Stage 1 Road Safety Audit

Mixed Use Development, Crown Square, Galway City

On behalf of **Crown Square Developments Ltd**

October 2018

SCHEMATIC ROAD CROSS SECTION
SCALE 1:25

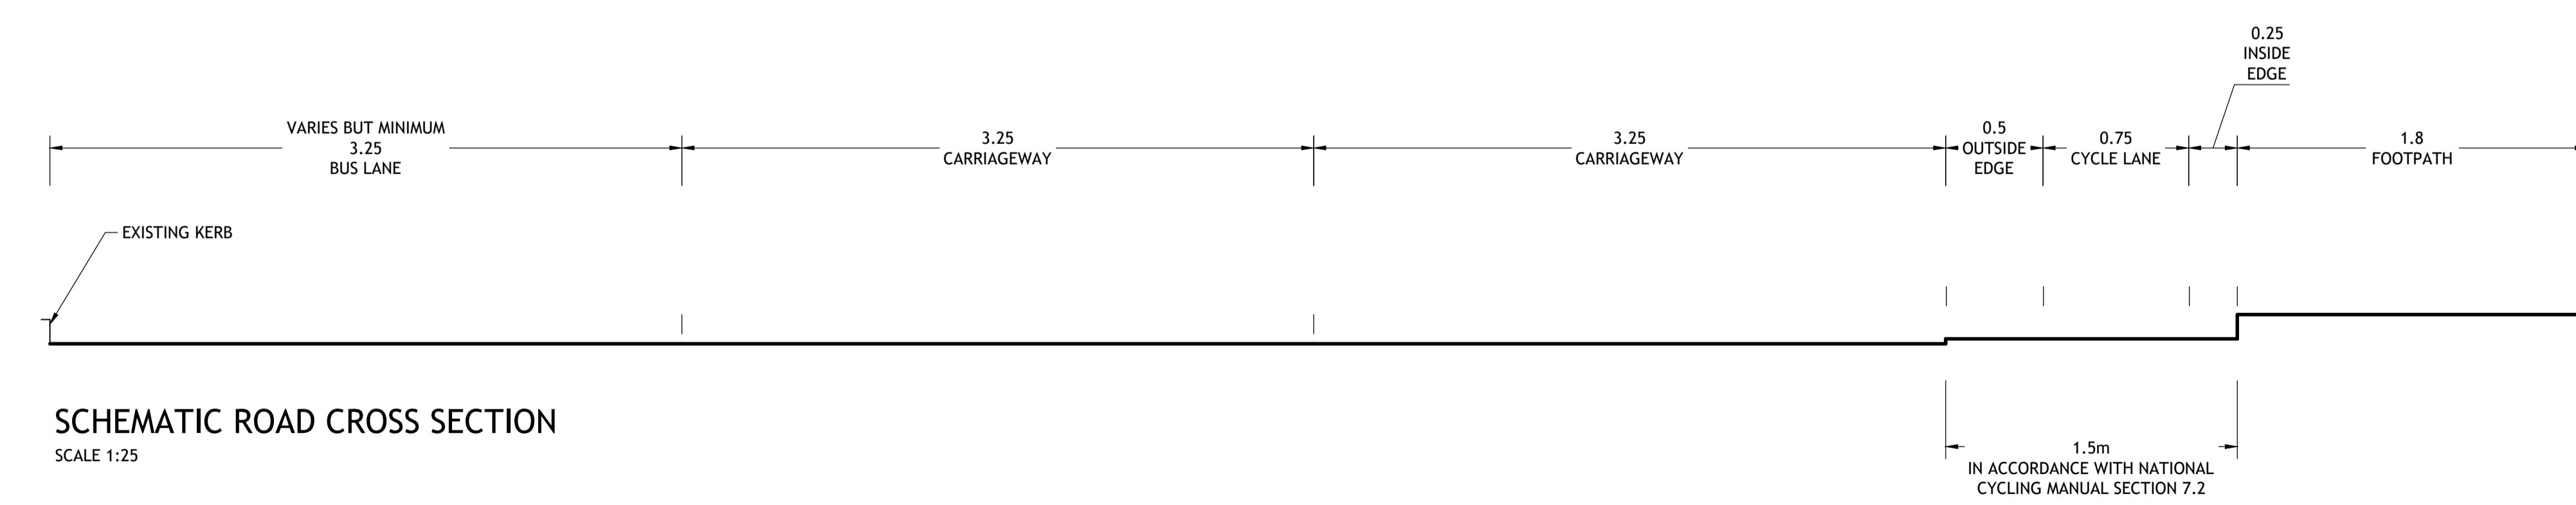
Problem: The proposed road cross section does not show any change in levels between the carriageway – cycleway – footpath.

Hazard: Vehicles may stray into vulnerable users' space.

Recommendation: Provide vertical segregation between the various users.

Problem: The cycle lane will be to an uphill gradient. The cross section indicates a 0.75m wide provision for cyclists. Differential speeds between cyclists is likely due to the uphill gradient.

Hazard: Cyclists overtaking slower cyclists are at risk of impact from main carriageway traffic.

Recommendation: Widen the cycleway.
